Application by Highways England for an Order Granting Development Consent for A428 Black Cat to Caxton Gibbet Improvements

The Examining Authority's written questions and requests for information (WQ1)

Issued on Friday 20 August 2021 (advance copy issued on Wednesday 21 July 2021)

Contains OS data © Crown Copyright and database right 2020
Contains public sector information licensed under the Open Government Licence v3.0
© Natural England material is reproduced with the permission of Natural England 2020. NB Local Nature Reserve dataset is "indicative" not "definitive".

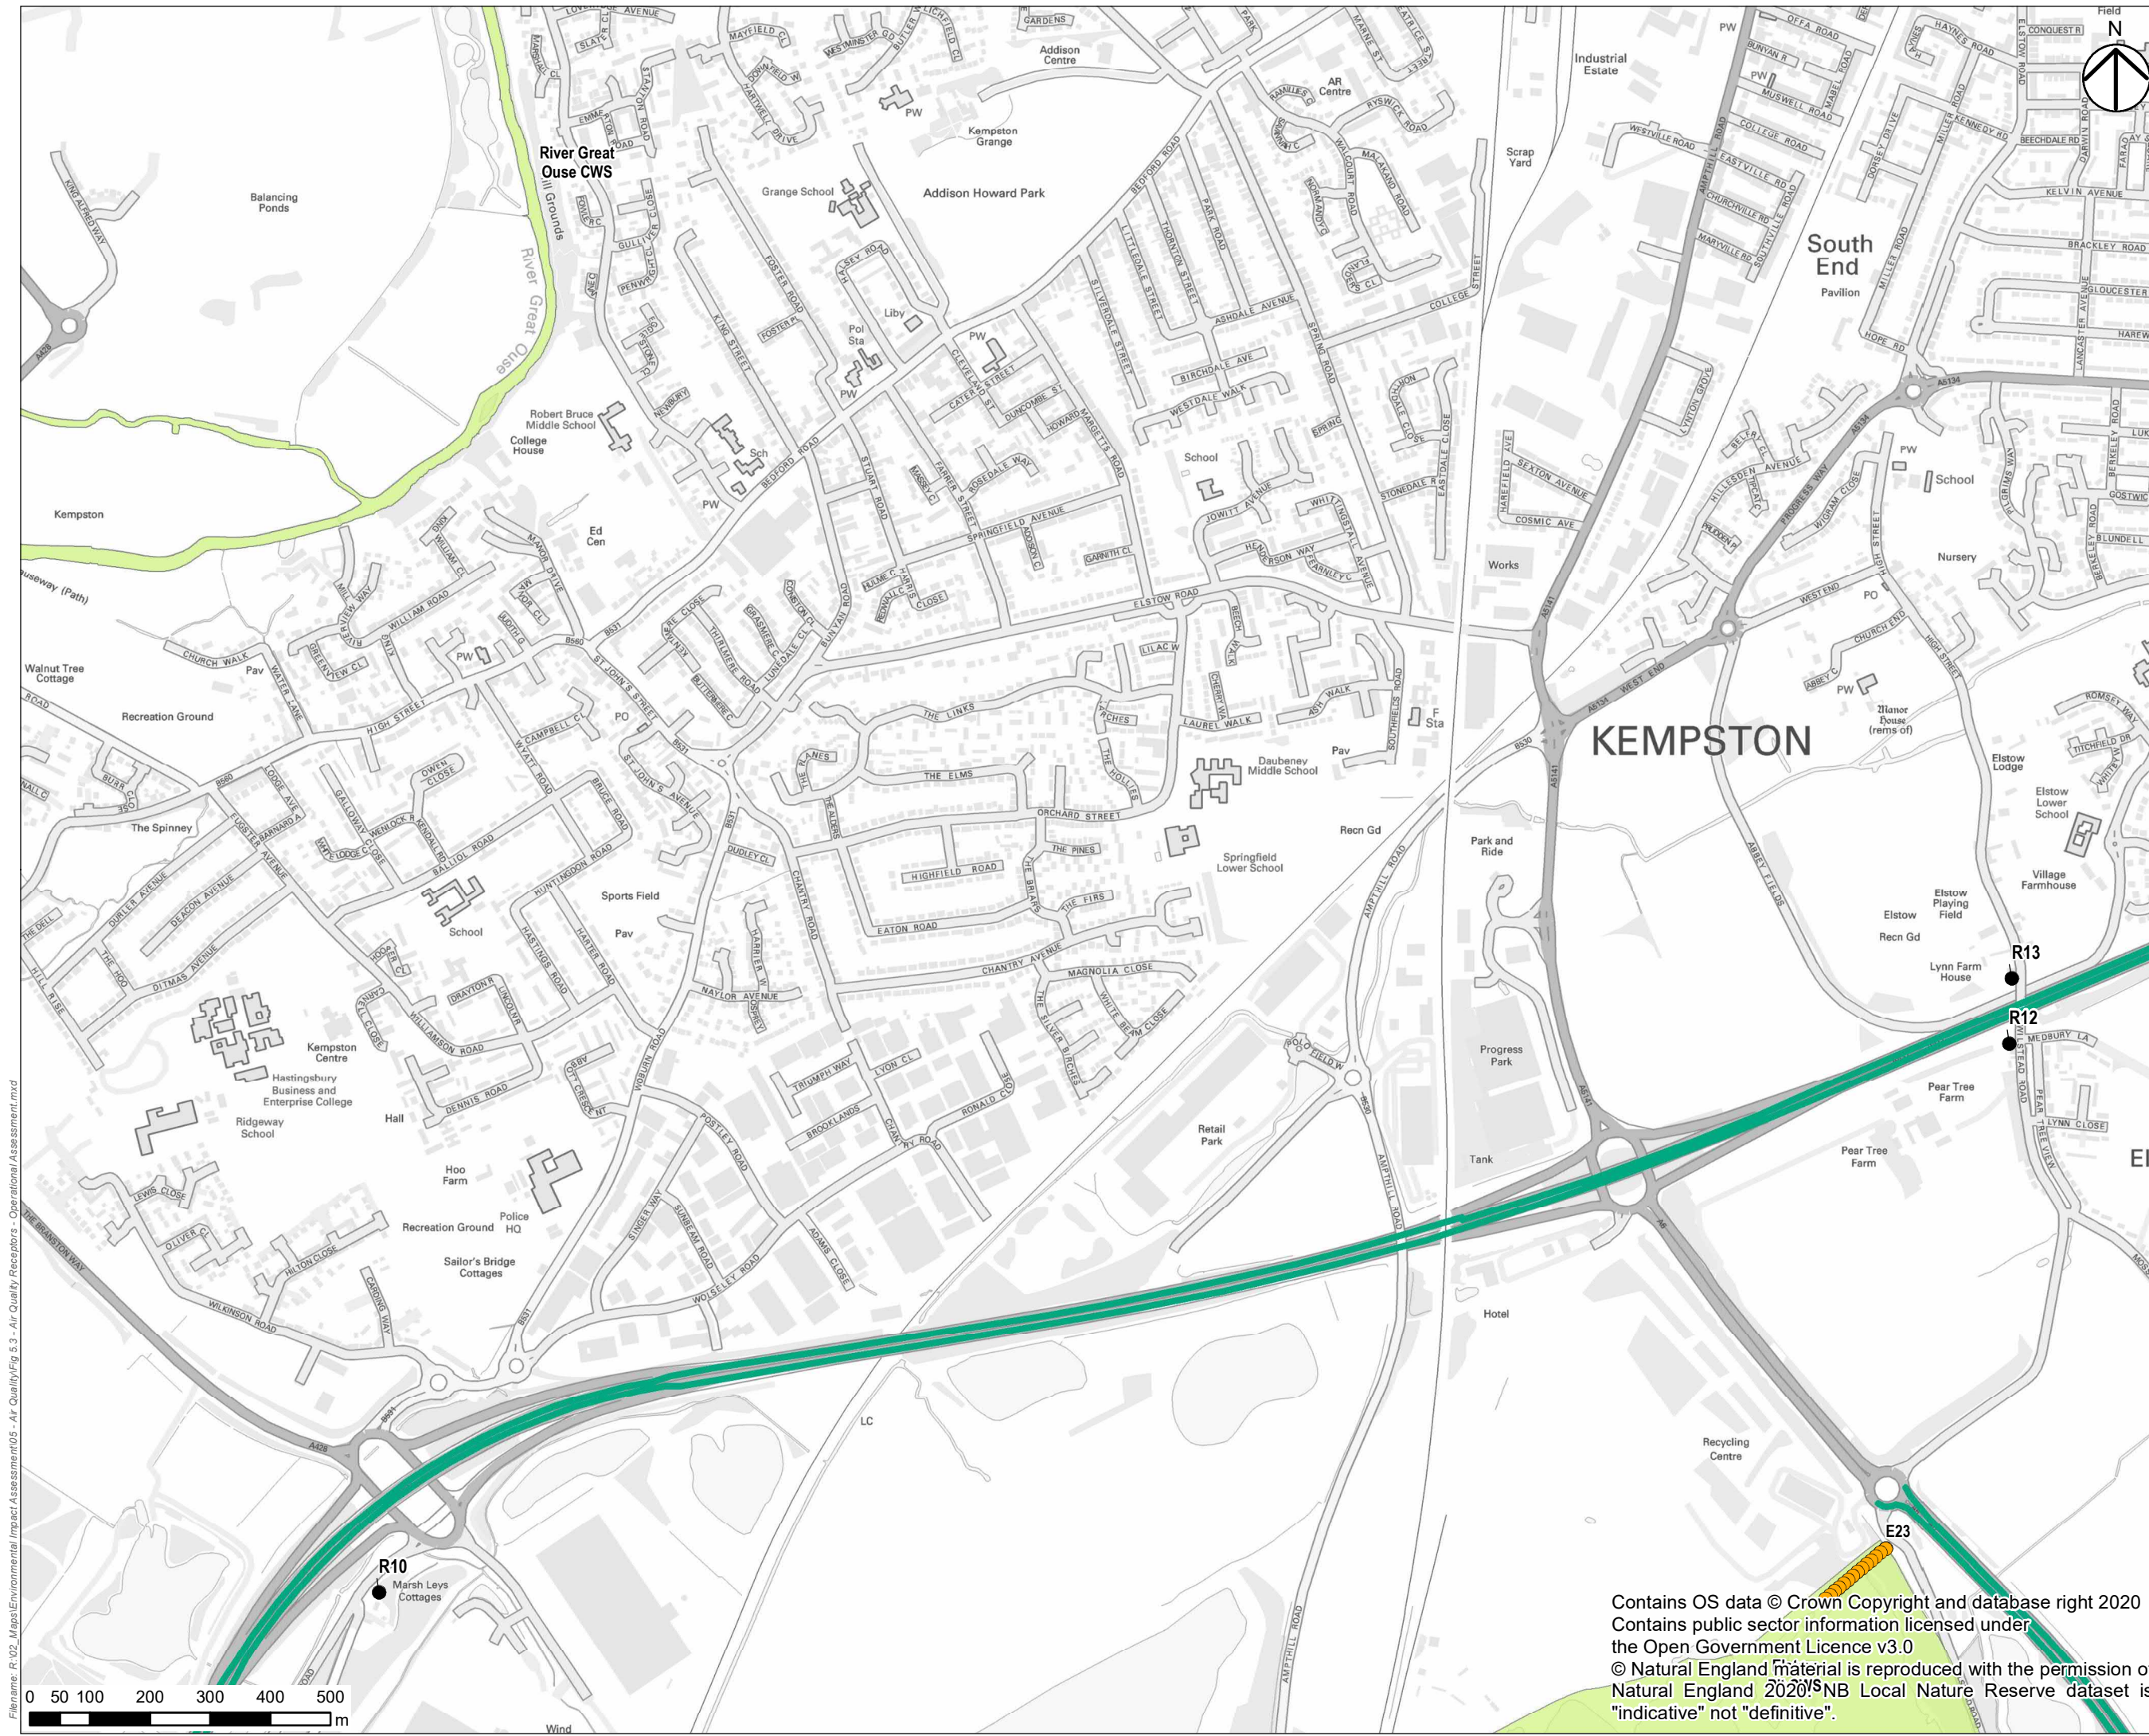
| Q1.1. General and Cross-topic Questions | | |
|---|--|---|
| Q1.2.1.1 | Local Authorities Public Health England | <p>Effects on receptors</p> <p>ES [APP-074, paragraphs 5.9.38 – 5.9.40] states that the Proposed Development would have no significant adverse effects on human health or designated habitats sites during either construction or operational phases of the scheme. Do LAs and PHE agree with this conclusion? Explain with reasons.</p> |
| Q1.2.1.2 | Central Bedfordshire Council | <p>Sandy Air Quality Management Area</p> <p>ES [APP-074, paragraphs 5.9.12–5.9.13] states that the magnitude of NO₂ change is predicted to be imperceptible at the 7 identified receptors in Sandy.</p> <p>a) Does CBC agree with this assessment? If not, explain with reasons.</p> |

| | | b) Are there other design options or measures that should be considered to improve air quality at this location? |
